**RE: 6/2021/2857/MAJ – TEWIN ROAD, WELWYN GARDEN CITY, AL7 1BD**

Following your objection letter dated 30<sup>th</sup> May 2022, please see responses to the comments you raised.

Drawing Title
Proposed Drainage Layout

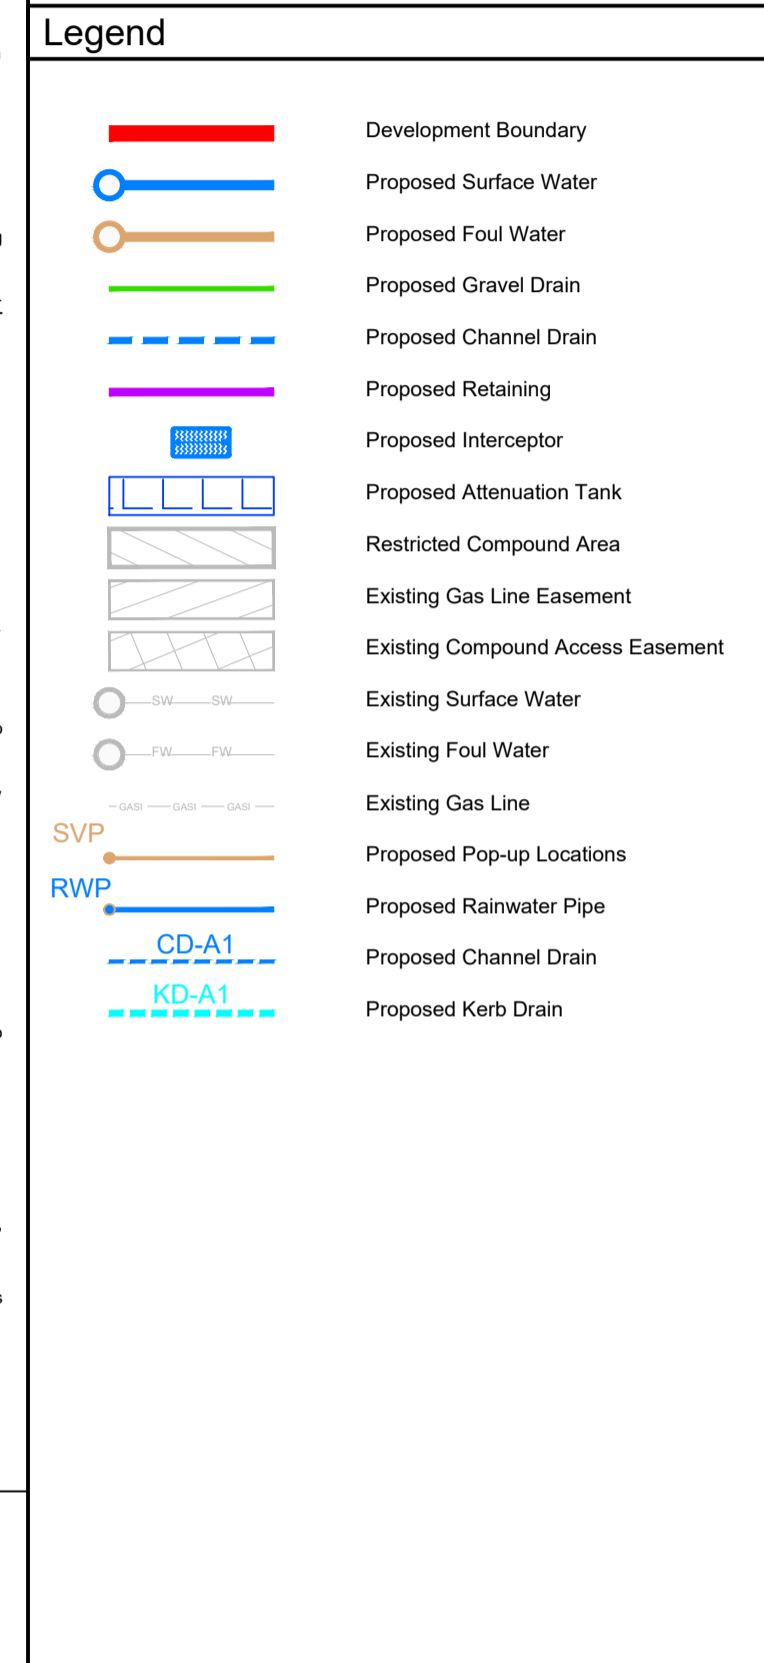
*"In addition, in Table 6.1 of the Drainage Strategy it is proposed to incorporate channel drain sumps and catchpit manholes in the proposed SuDS features however, the location of some proposed SuDS measures, pipe runs, discharge points and informal flooding is not included on this final drainage layout. This should be updated and appropriately indicated on a drawing."*

**BWB response:** This is now shown on the revised drawing ref. TRW-BWB-GEN-XX-DR-C-0500\_Proposed Drainage Layout.
